**Re:** BusConnects Galway Cross-City Link Scheme.  
University Road to Dublin Road, Galway City.

**RE: HA61.314597 University Road to Dublin Road, Galway**

**Proposed development: - BusConnects Galway- An Bord Pleanála – SID Application**

**REPORT NAME** THE COURTS SERVICE BUSCONNECTS GALWAY  
**SUBMISSION**

Role	Transport Infrastructure
Suitability	Planning
Arup Job No	253352-00
Name	BCG-GA-00-02
Rev	PL01

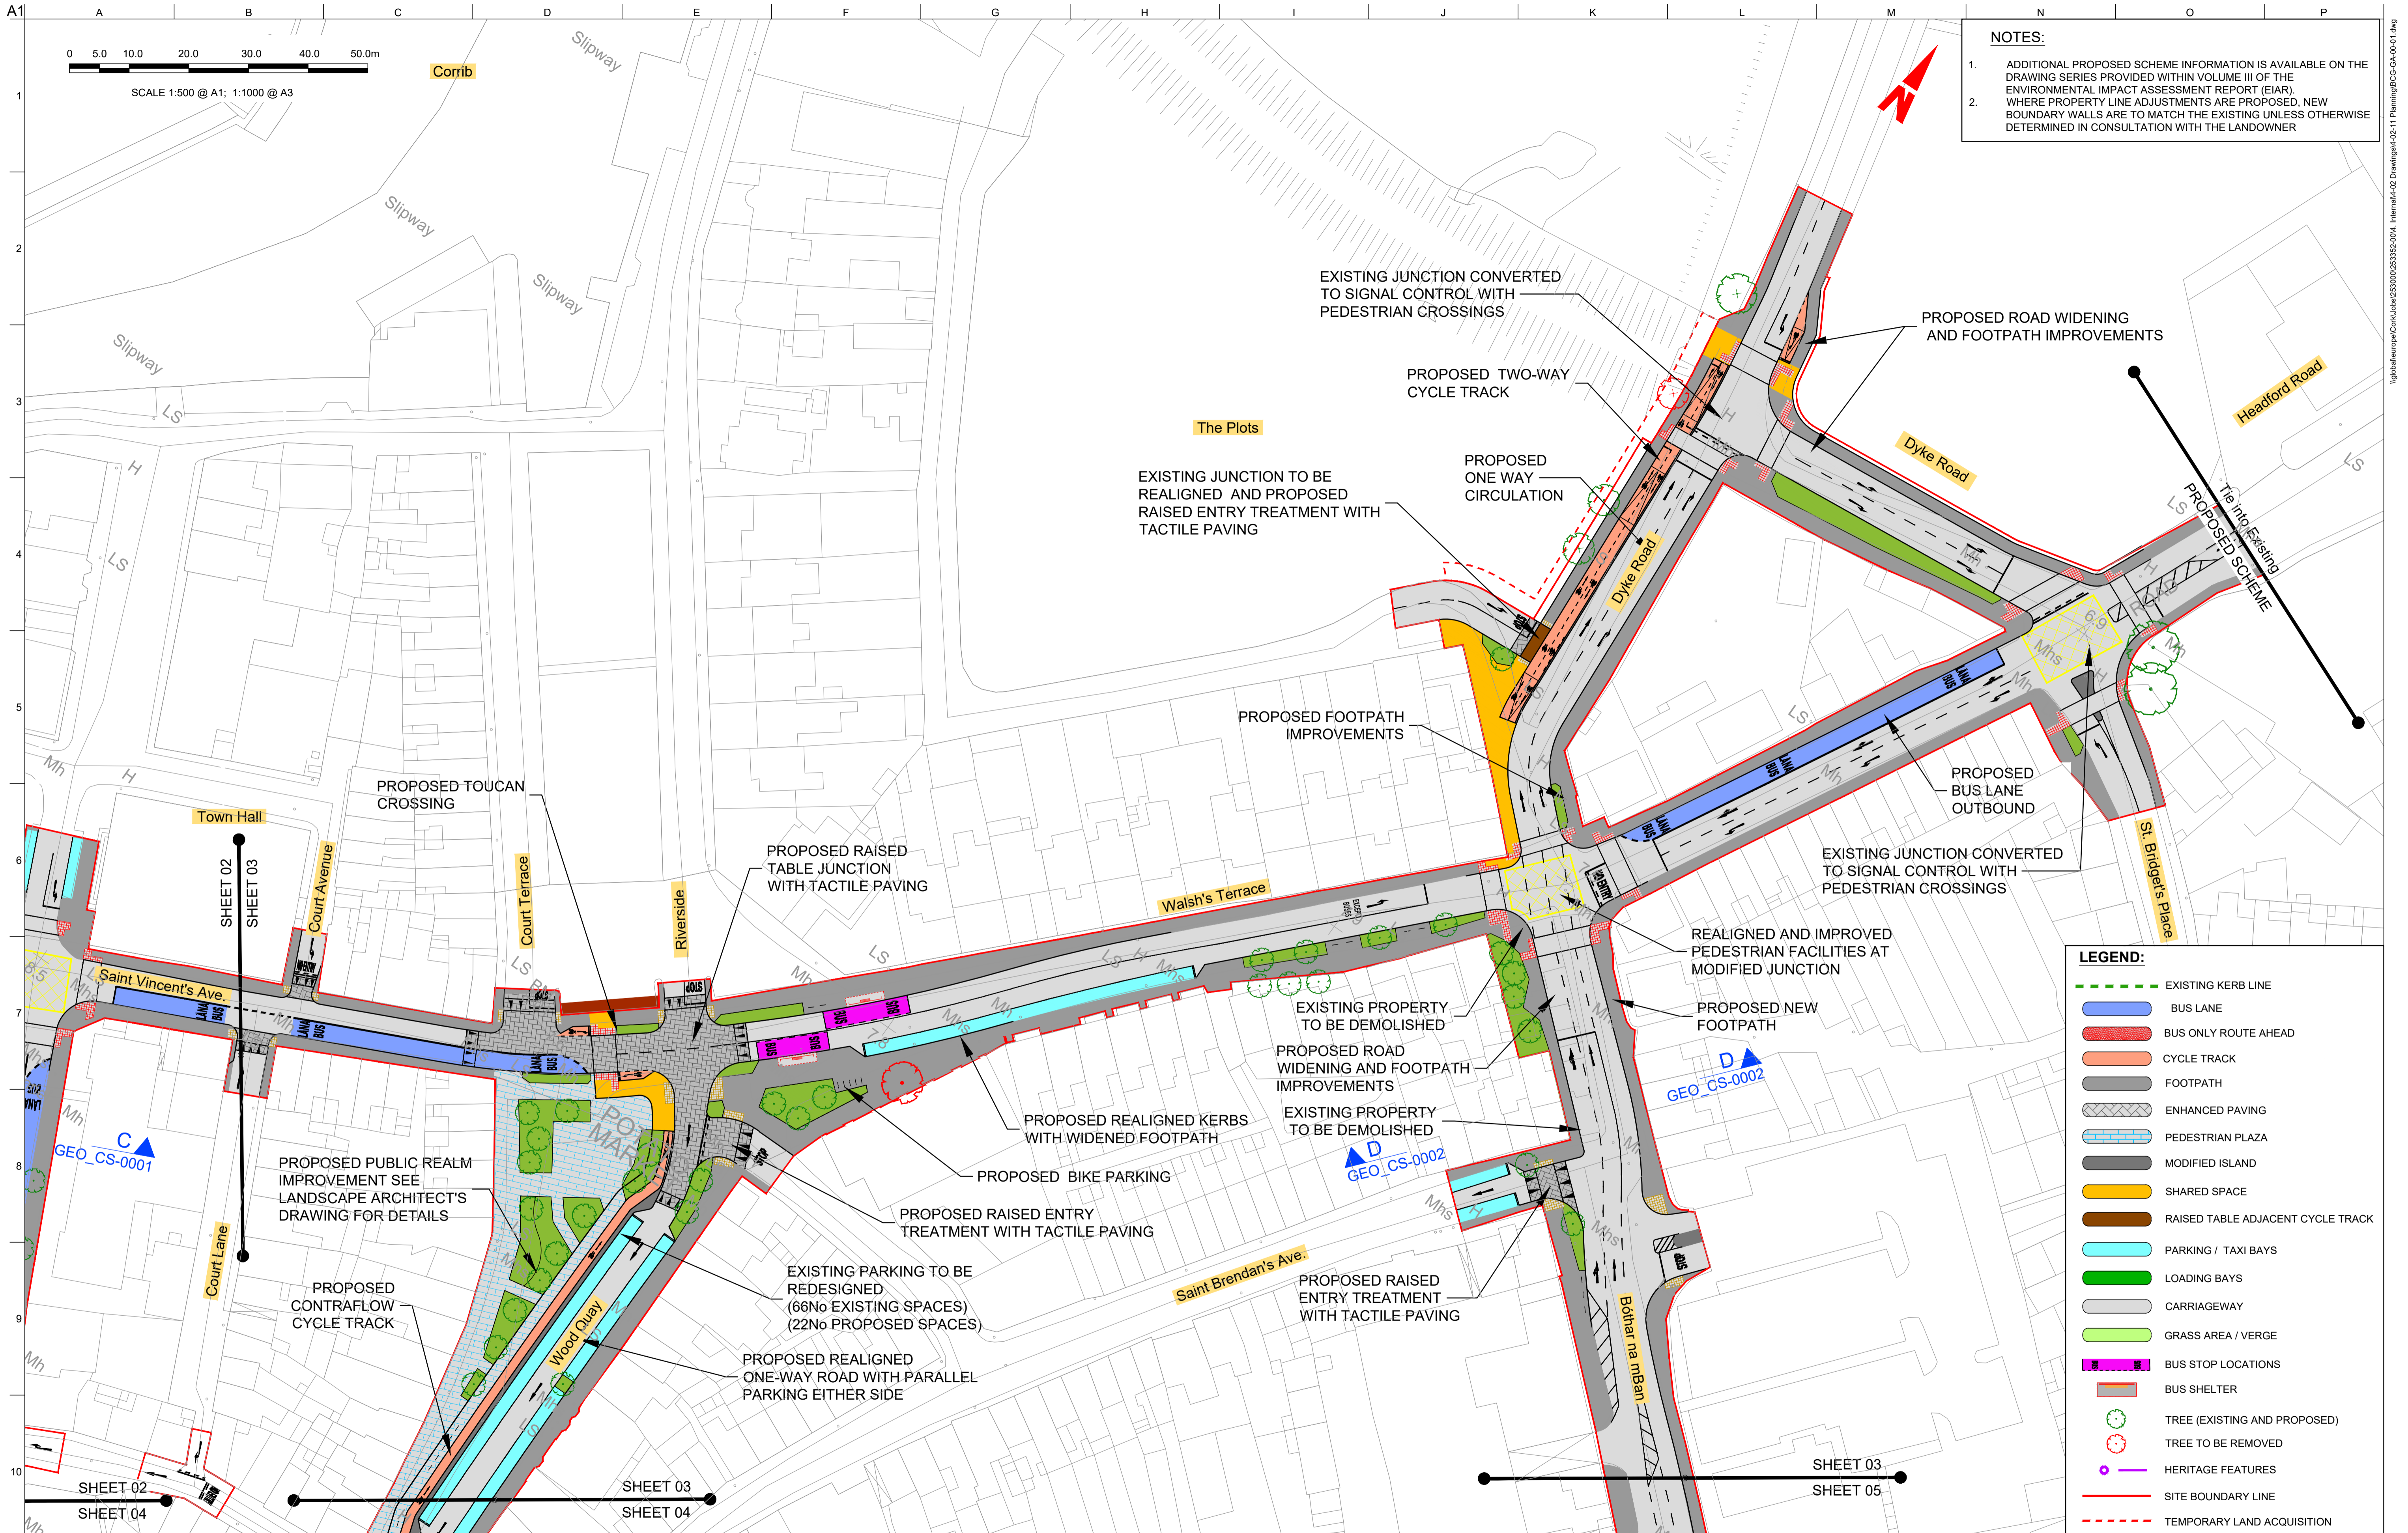
The Newtownsmith sub-section General Arrangement design is illustrated on BCG-GA-00-02. The design provides a single traffic lane (pedestrianised and bollard controlled) ; having a width of 4.0m. A footpath of width 2.0m to 5.6m is provided in both directions.

The Courts Service have concerns with the proposals of this section on the route (**3.2.3 Newtownsmith/St. Francis Street**) in terms of the general arrangements for the circulation around the courthouse and access to the west and north of the courthouse, and the proposed hard and soft landscaping, which will be outlined in section 4 below.

Galway Courthouse and its continued operation as a functioning courthouse, has a unique set of requirements for high levels of security and safety, which means the proposals which restrict access, circulation and parking as outlined in BusConnects Galway (as published) compromise that safe and secure operation.

Figure 6 below highlights the area which is the focus of the objection to the BusConnects Galway proposal. This is specifically the area to the west and north of the Courthouse.
